Yapton PC Comment

17/07/2025

Planning Reference F/19/25/OUT

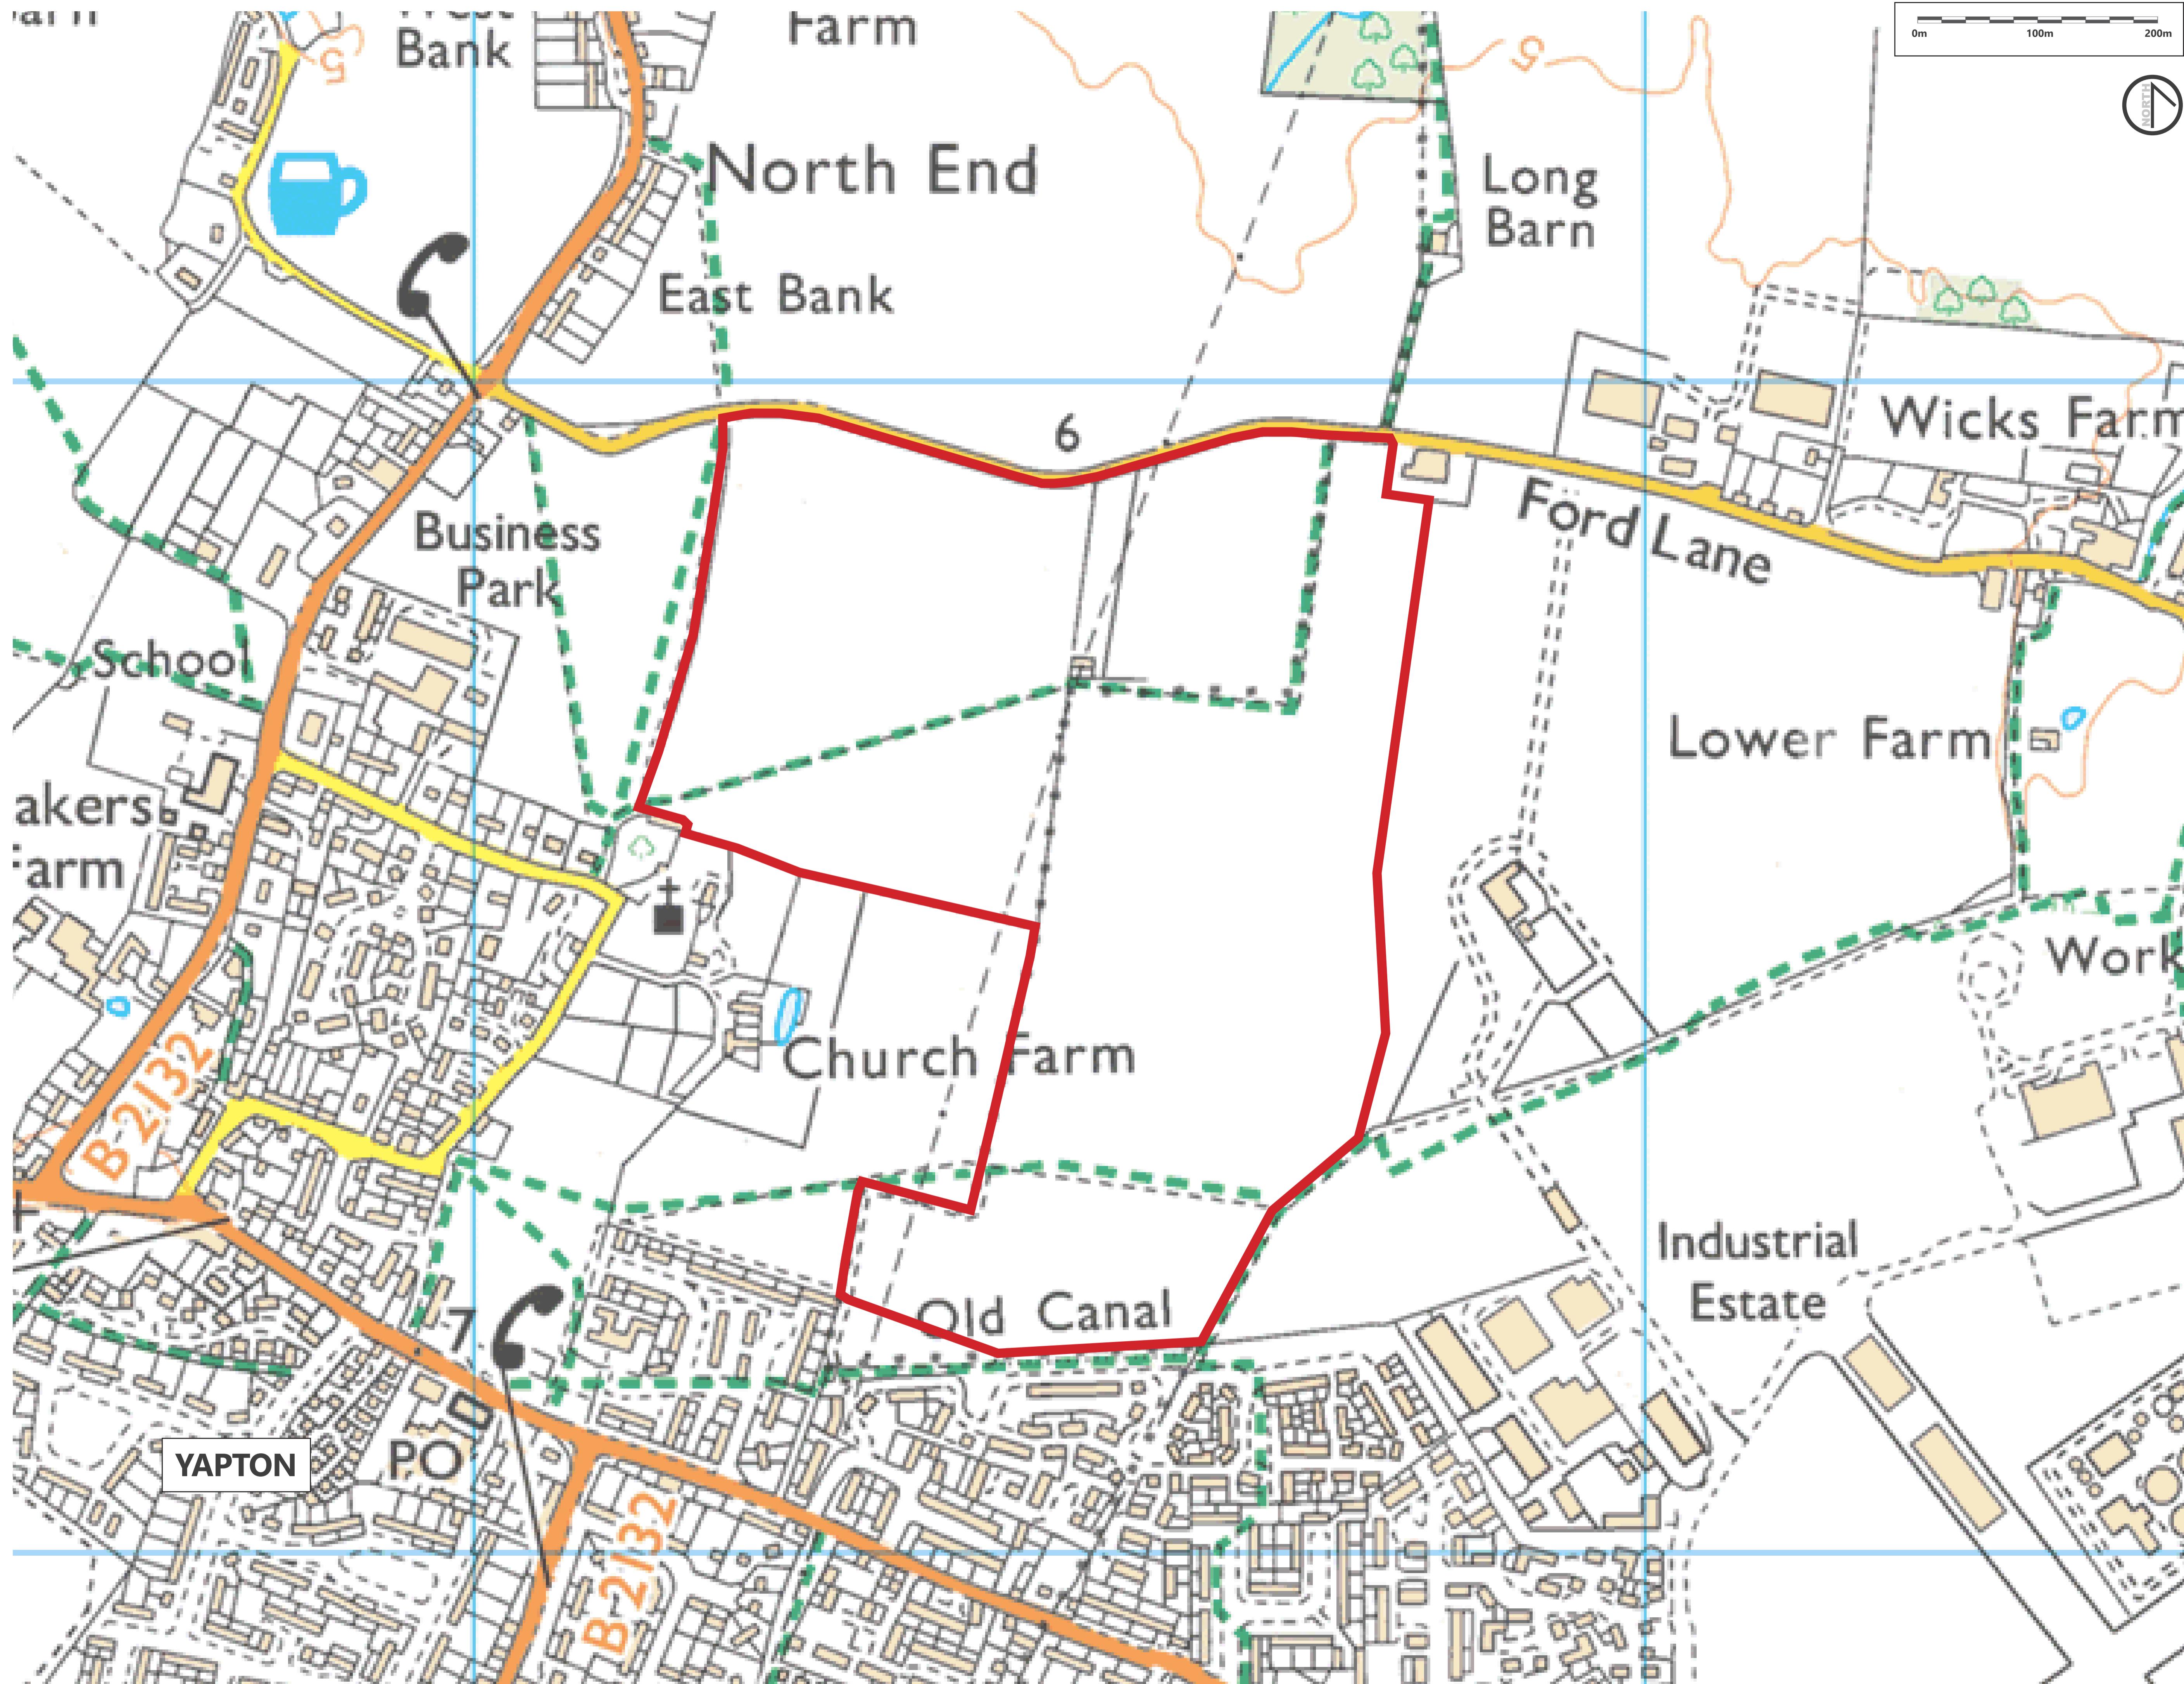
YPC acknowledge that in general master planning terms, the Illustrative Masterplan 401-UW-P-002, represents land parameters with the least impact on adjoining uses and synergy with potential future uses. Should any development take place in this location YPC would expect these land parameters to be maintained and only in this form moved forward in the planning process. YPC would insist that should this application be looked on favourably, the land parameters are conditioned to be maintained to reflect the current illustrative master plan.
